**WELWYN HATFIELD BOROUGH COUNCIL – DEVELOPMENT MANAGEMENT
DELEGATED REPORT**

APPLICATION No:	S6/2012/2404/FP
APPLICATION Site:	Oshwal Centre

The application requires a new glazing facade to an existing assembly hall to facilitate internal changes to create a new lift.

PROPOSED ELEVATIONS

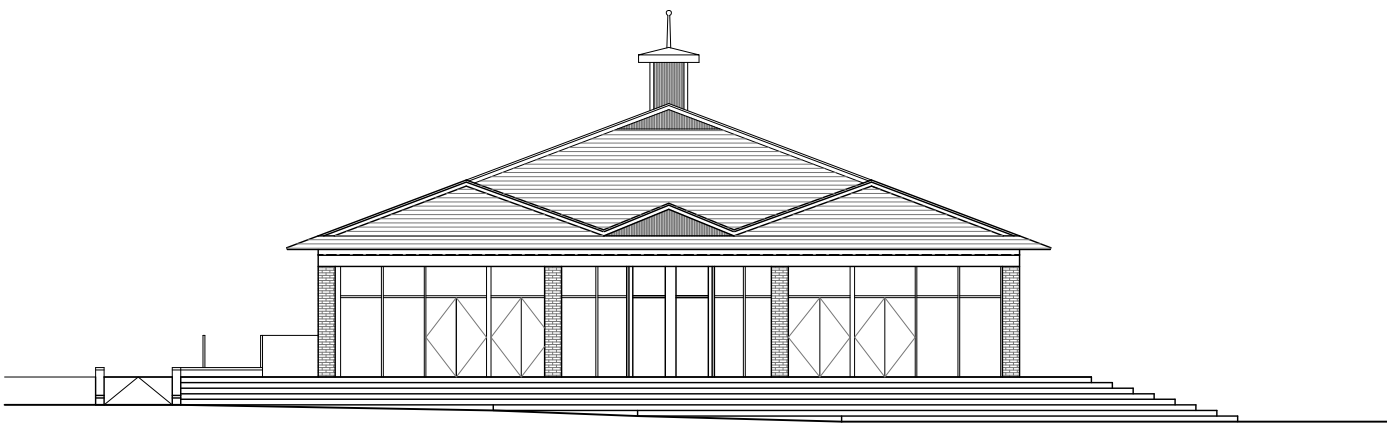
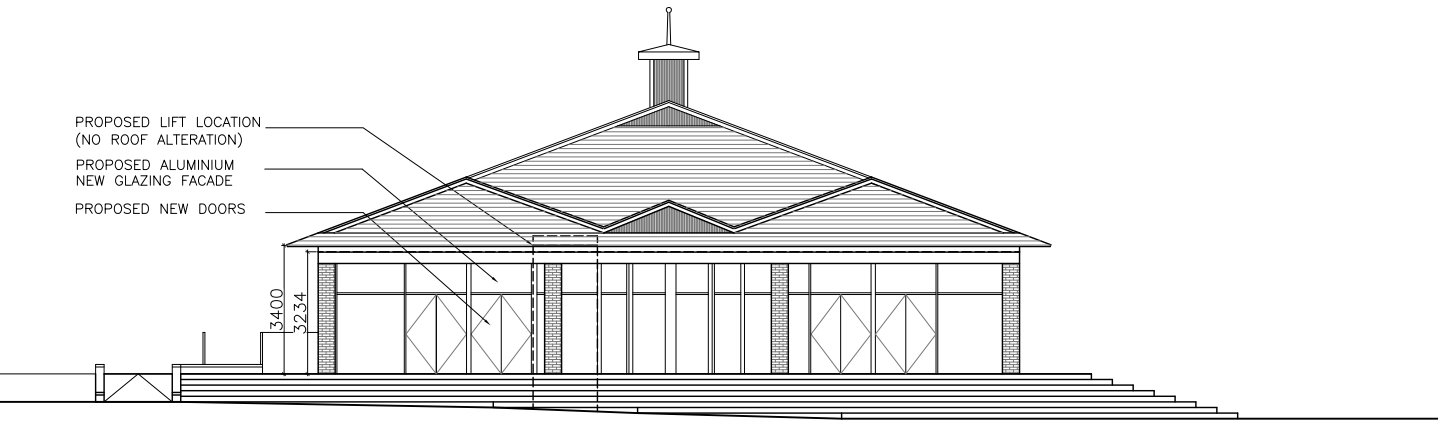
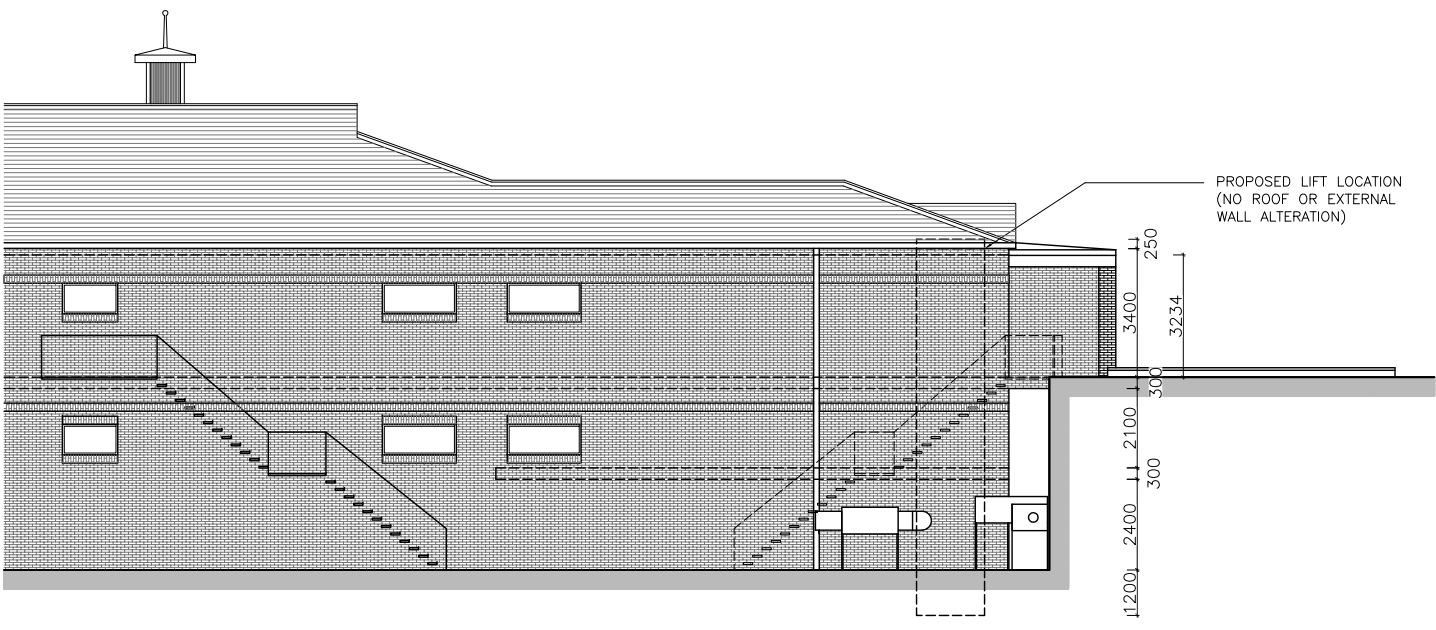
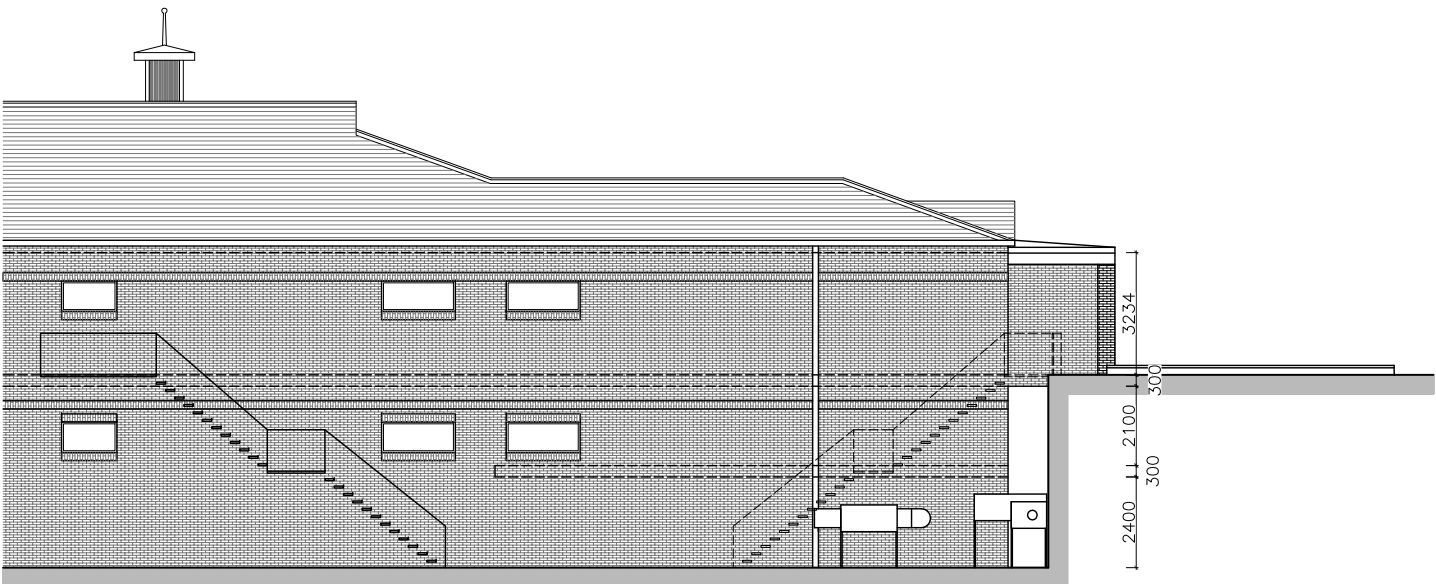
In this application, an alteration is proposed to the existing assembly hall which requires the removal of an existing glazed entrance screen under the canopy of this building and its replacement with a new screen to allow the opportunity to allow a new lift to be inserted.

Although the proposal will result in some change to the external appearance of the current building, this is very limited, as views are screened in part by the overhang of the existing entrance canopy. The design of the proposed glazing is also very

similar to the existing, and so the overall impact on the character of the surrounding area will not be significant.

The quality of the design has already been considered in a part with regard to the visual amenity assessment above. The proposed design is considered to be in keeping with the character of the existing building as the design of the glazing replicates very closely the style which it is to replace.

The application form indicates that the existing framework of the glazing is aluminium and that the proposed will also be the same. The applicant stated on site that the proposed finish will match that of the existing polished metal and so a planning condition requiring the use of matching materials will be adequate.

3. The external finishes of the approved extension/alterations shall match the existing, unless otherwise approved in writing by the local planning authority.
